**Section 75W Modification to Project Approval (MP09\_0217) at 120-128 Herring Rd, Macquarie Park for Staged Subdivision**

This letter accompanies an application made under Section 75W of the Environmental Planning and Assessment Act 1979 with respect to a proposed modification to Major Project Approval MP09\_0217 that granted Project Approval for *Staged Subdivision* of the site.

Drawing No.	Revision	Name of Plan	Date
091120.DP.STG1A	8	Sheet 1 of 3	2/3/2011
091120.DP.STG1A	8	Sheet 2 of 3	2/3/2011
091120.DP.STG1A	8	Sheet 3 of 3	2/3/2011
091120.DP.STG2	8	Sheet 1 of 3	2/3/2011
091120.DP.STG2	8	Sheet 2 of 3	2/3/2011
091120.DP.STG2	8	Sheet 3 of 3	2/3/2011

Surveyor: CAMERON PHILLIP MILES Date of Survey: 05/01/2010 Surveyor's Ref: 091120.DP.STG1A	PLAN OF SUBDIVISION OF LOT 1 IN D.P. _____  STAGE 1A	LGA: RYDE Locality: MACQUARIE PARK Subdivision No: Lengths are in metres. Reduction Ratio 1: 750	REGISTERED	DP
--	--	---	------------	----

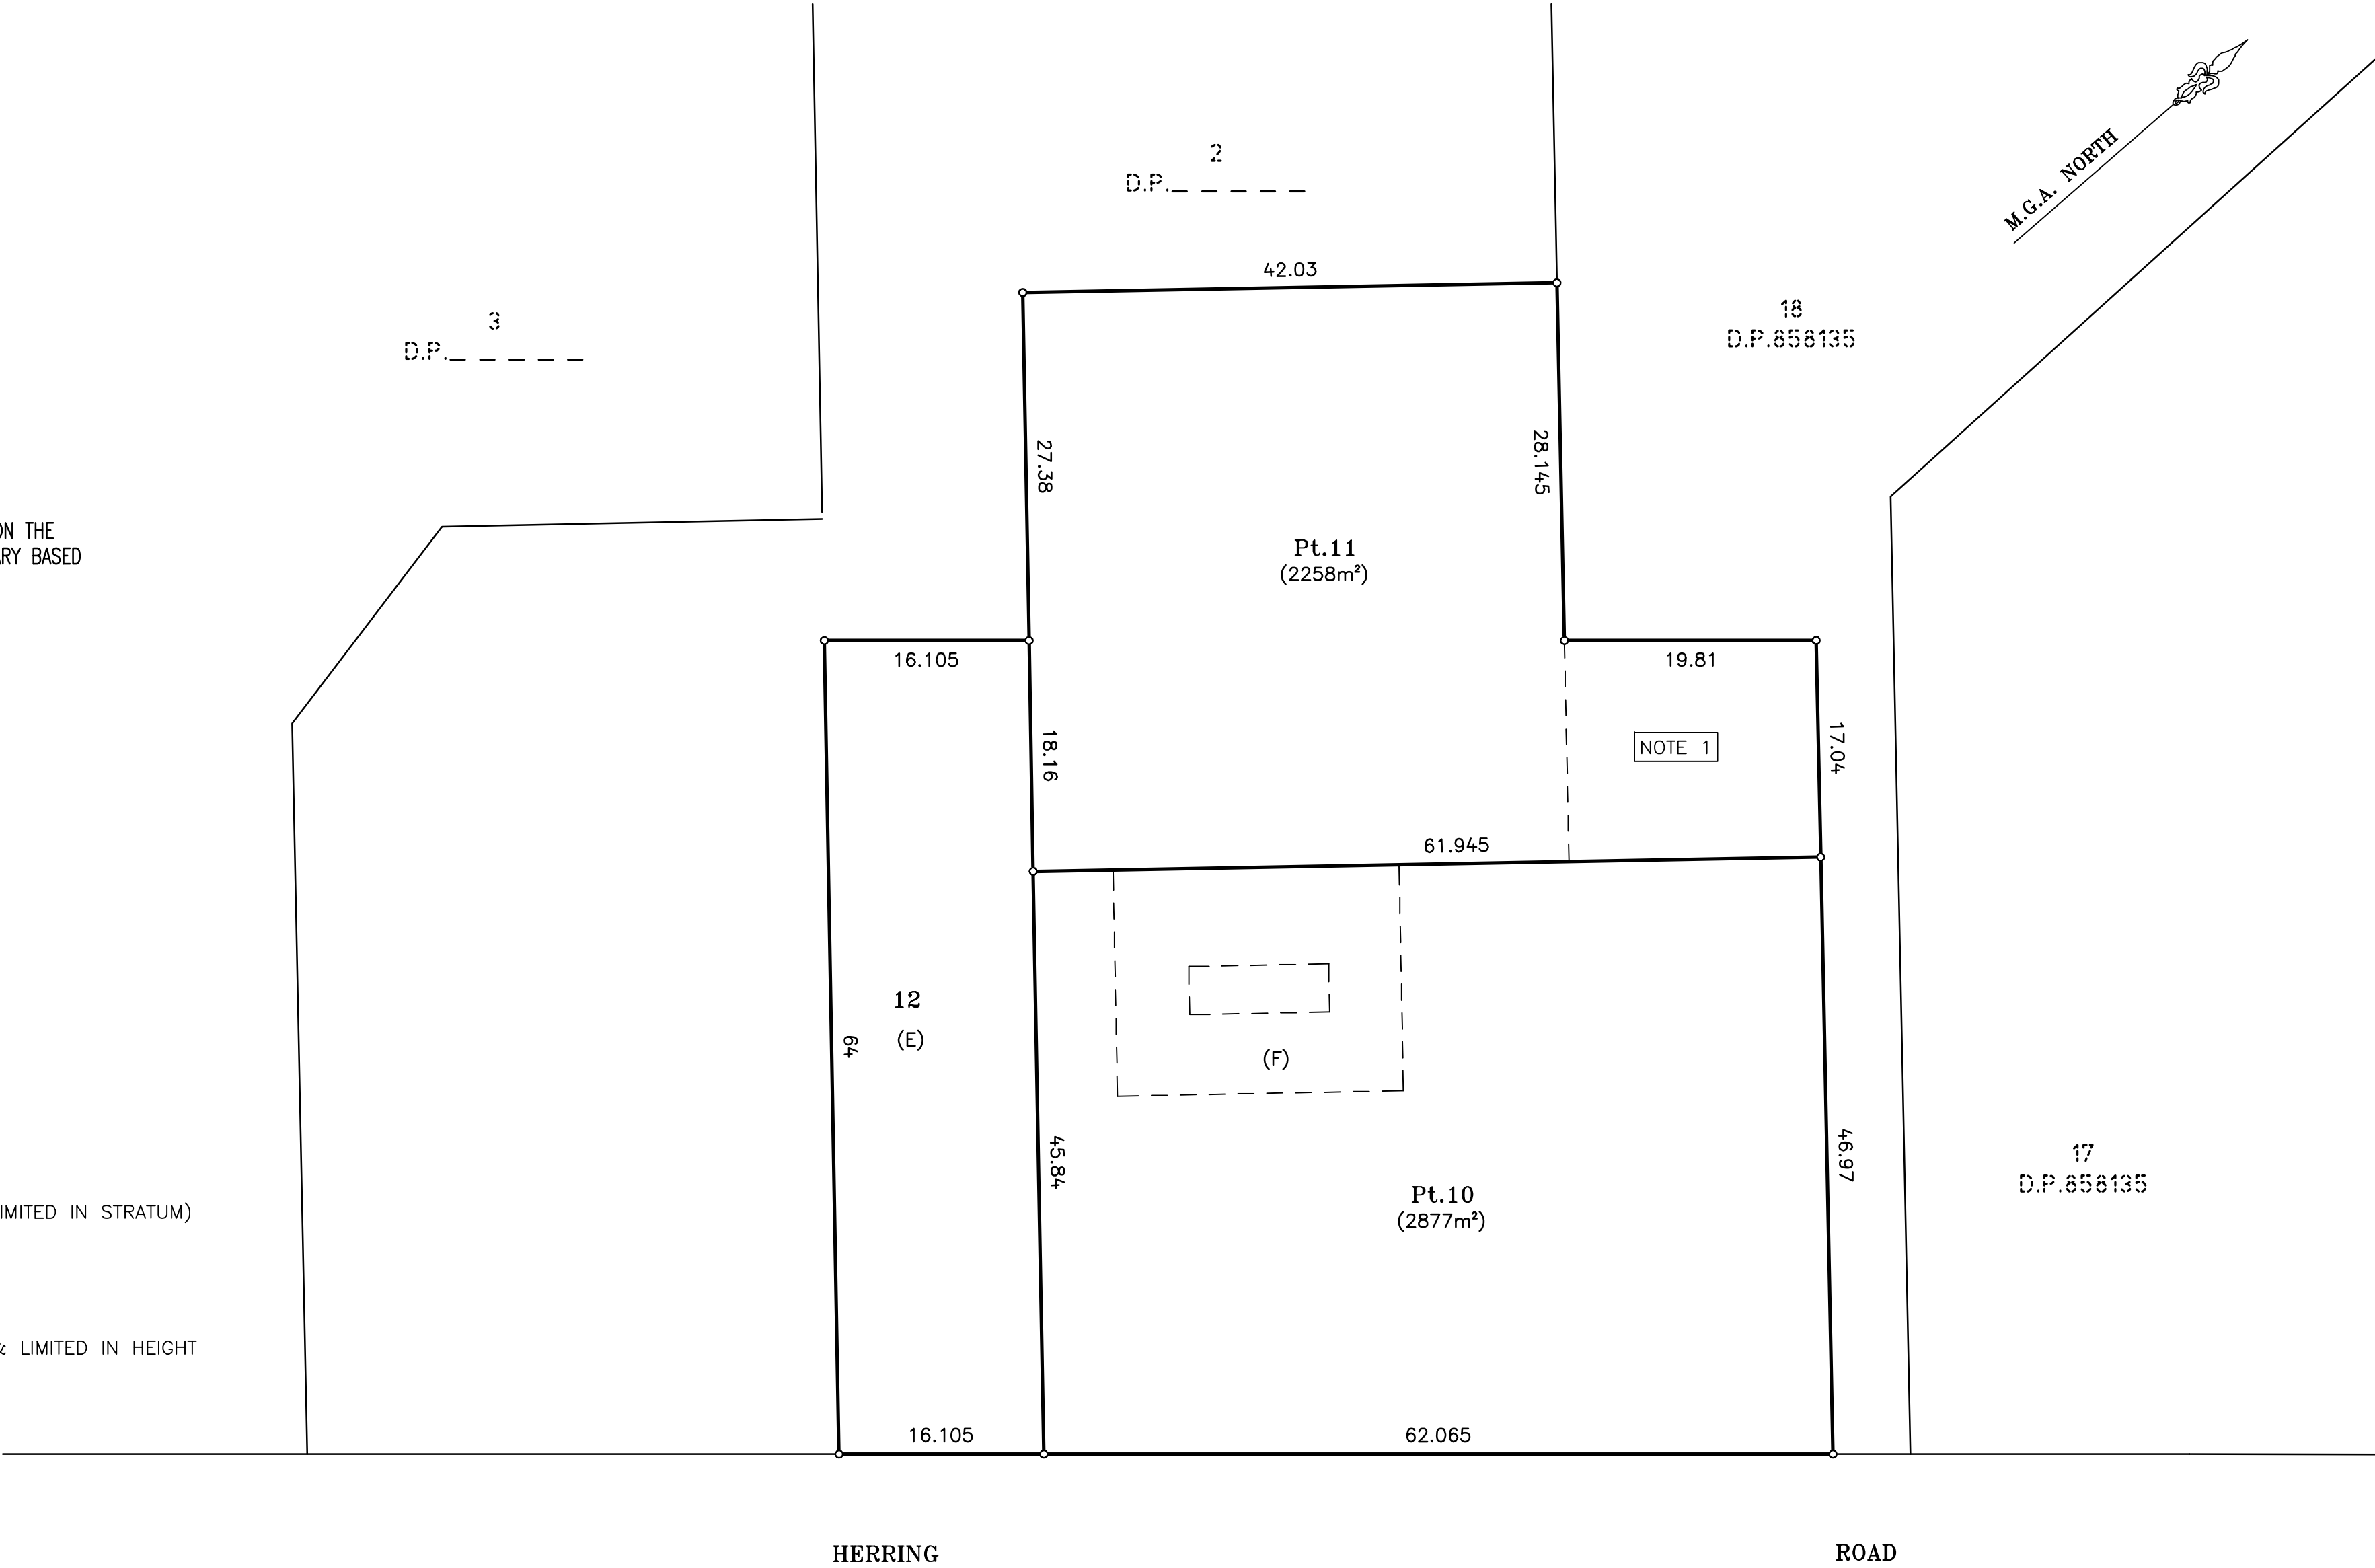
- Condition B1 of the Project Approval requires modifications to the plans to ensure that they are worded to identify the easement for access will be for pedestrian and cycleway a minimum of 2.5m in width across proposed Lot 11; and
- To rectify some minor drafting errors with respect to certain numeric measurements of the Stage 2 summary plan.

The notation on the Stage 1A Subdivision Plan (Proposed Lot 11) for the proposed easement for access is proposed to be amended to remove the previous reference as a "Right of Footway Variable Width (x)" to be now known as an "**Easement for Access (Pedestrian and Cycle) 2.5 wide (x)**". This change will make it clearer as to the prescribed use of the access as well as the dimensions, in accordance with the requirements of Condition B1 of the Project Approval.

Surveyor: CAMERON PHILLIP MILES Date of Survey: 05/01/2010 Surveyor's Ref: 091120.DP.STG2	PLAN OF SUBDIVISION OF LOT 2 IN D.P. _____ STAGE 2	LGA: RYDE Locality: MACQUARIE PARK Subdivision No: Lengths are in metres. Reduction Ratio 1: 750	REGISTERED	DP
---	---	---	------------	----

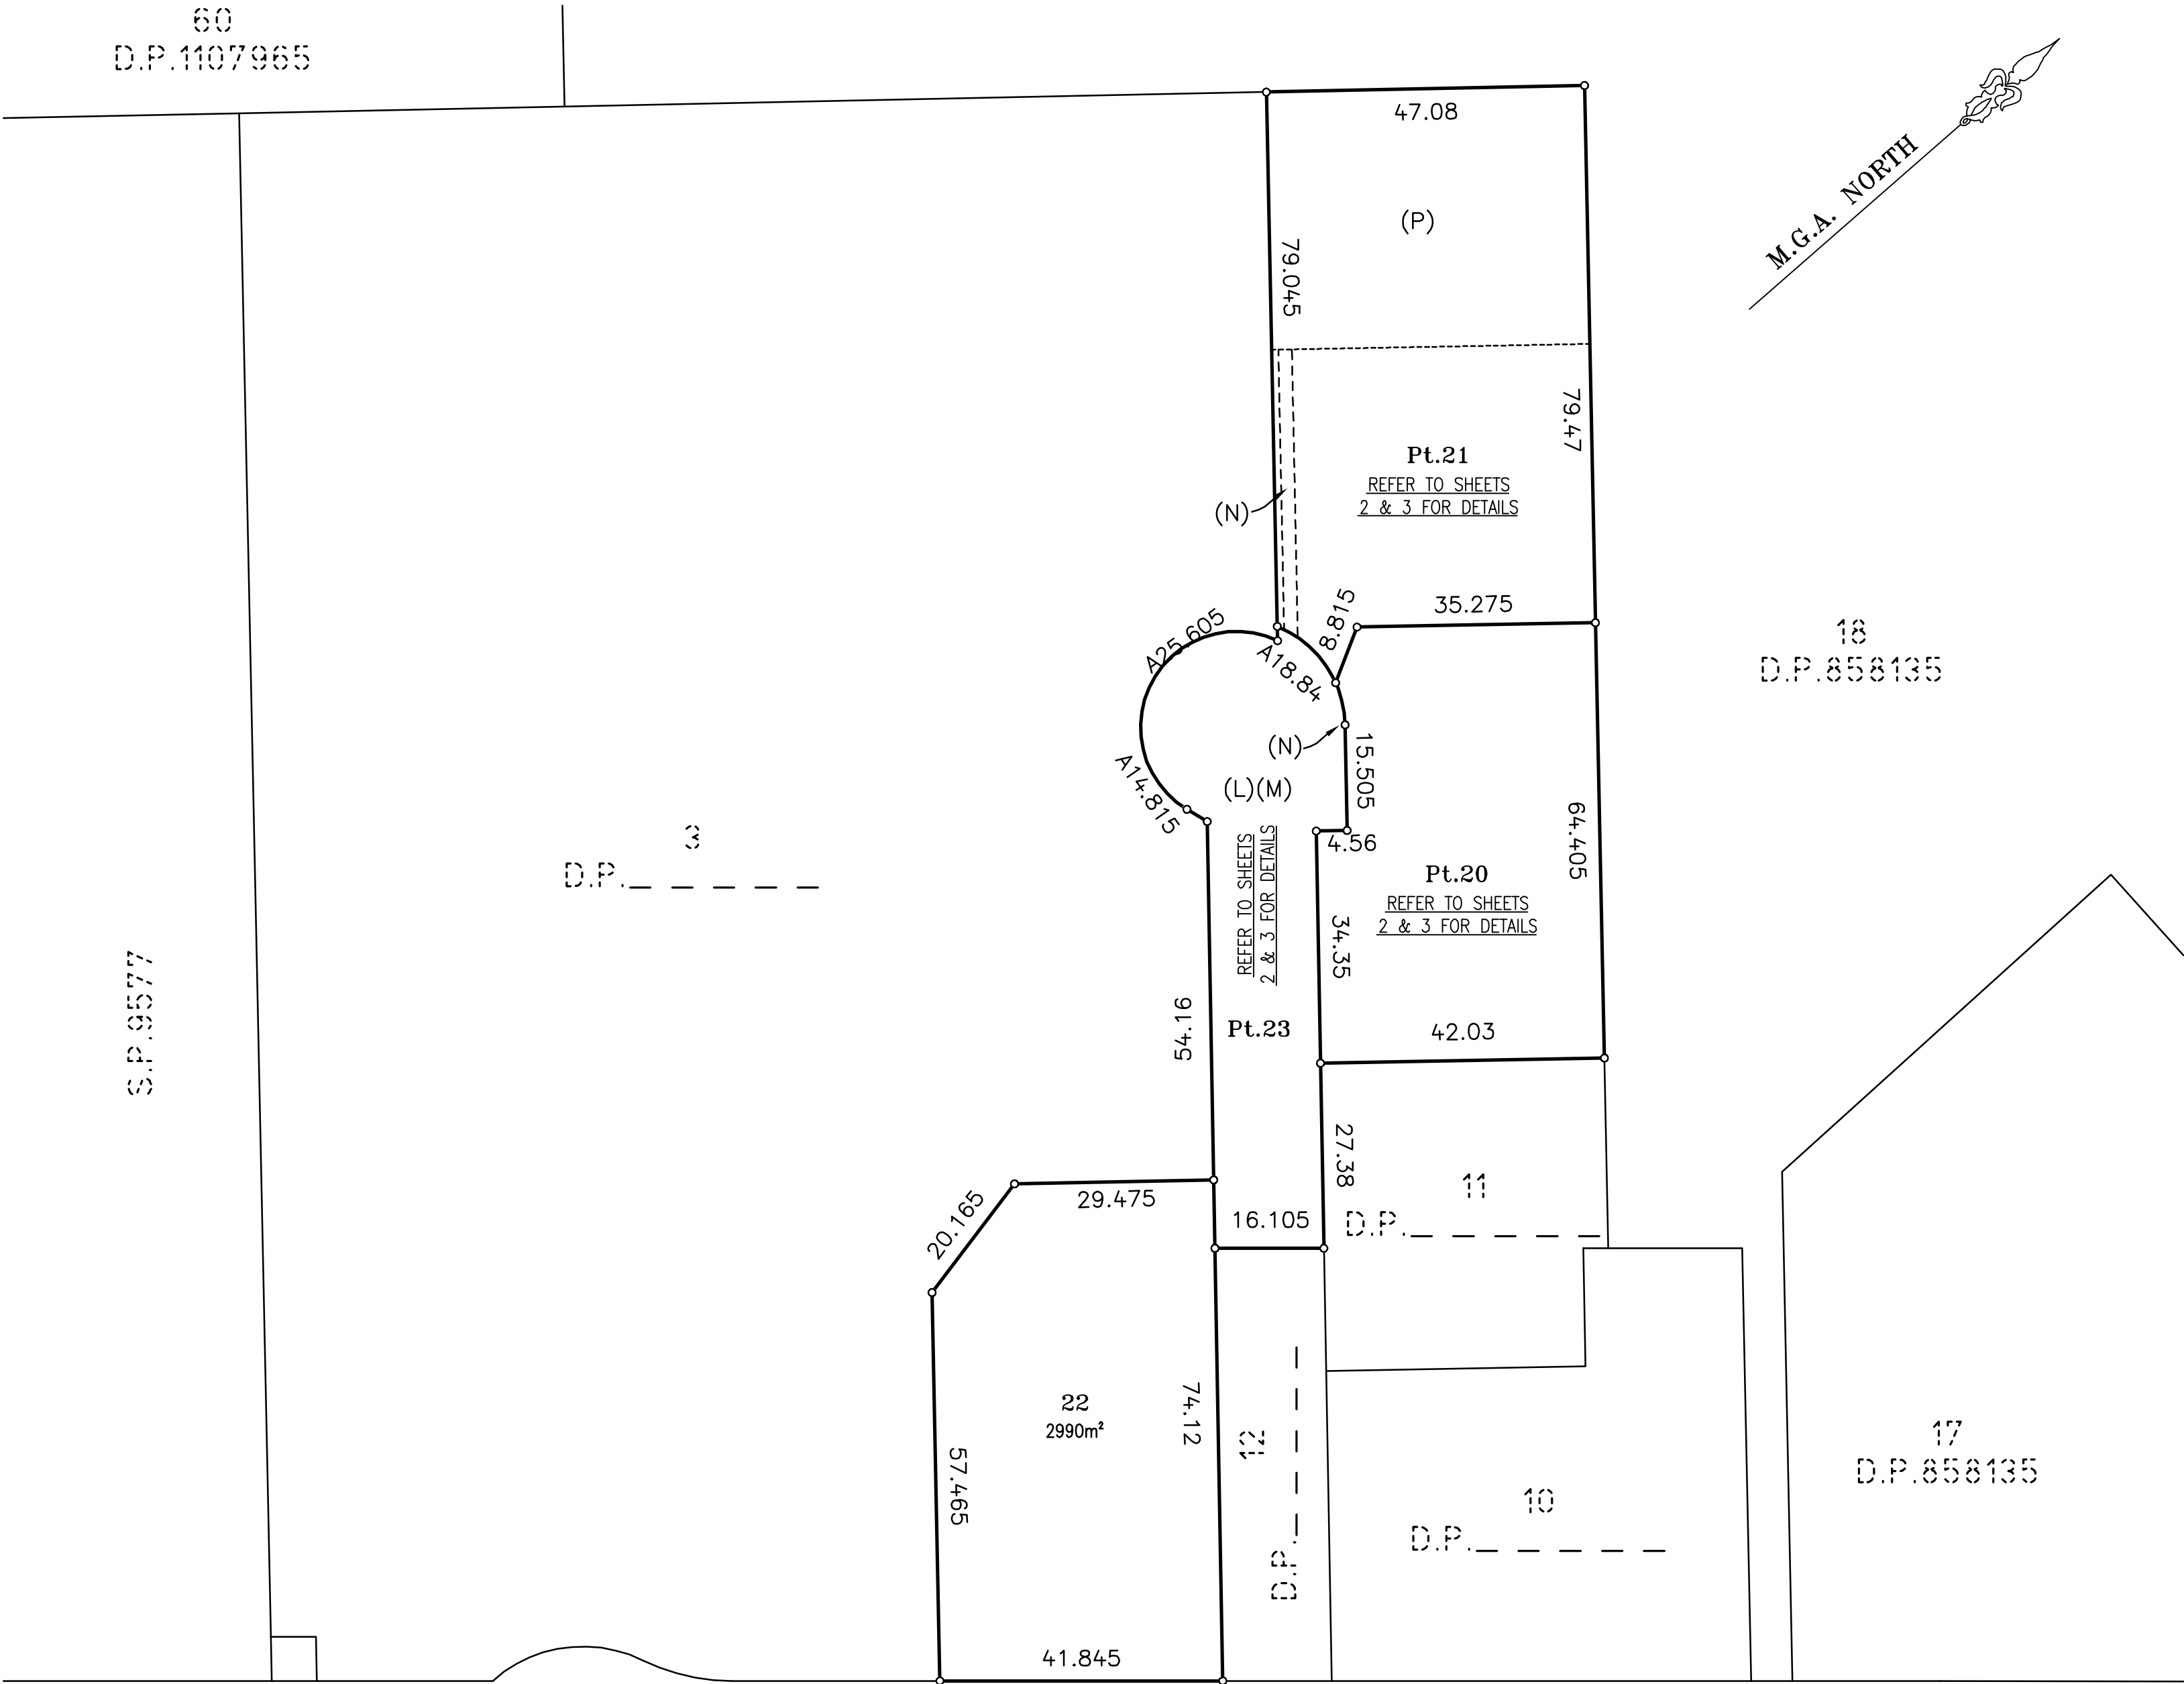
The other amendment to the plans is very minor as they relate to some minor errors to the dimensions on Sheet 1 of the Stage 2 Subdivision Plan. Sheet 1 is the "summary" sheet for the Stage 1A subdivision, with the following Sheets 2 and 3 providing the detailed drawings for the subdivision. The labelling of some dimensions along the road and the cul-de-sac on the Sheet 1 summary sheet were not updated to reflect the minor design change to the cul-de-sac that occurred during the submission of the PPR. The dimensions on Sheets 2 and 3 remain unchanged as they are correct and therefore the proposed changes will ensure the summary dimensions on the summary sheet are consistent with the detailed sheets.

After re-looking at the plans a minor error was discovered on the summary Sheet 1 for the Stage 2 drawings, and therefore the updated plans will ensure that the dimensions are consistent with those shown on the approved Sheets 2 and 3 of the Stage 2 subdivision.
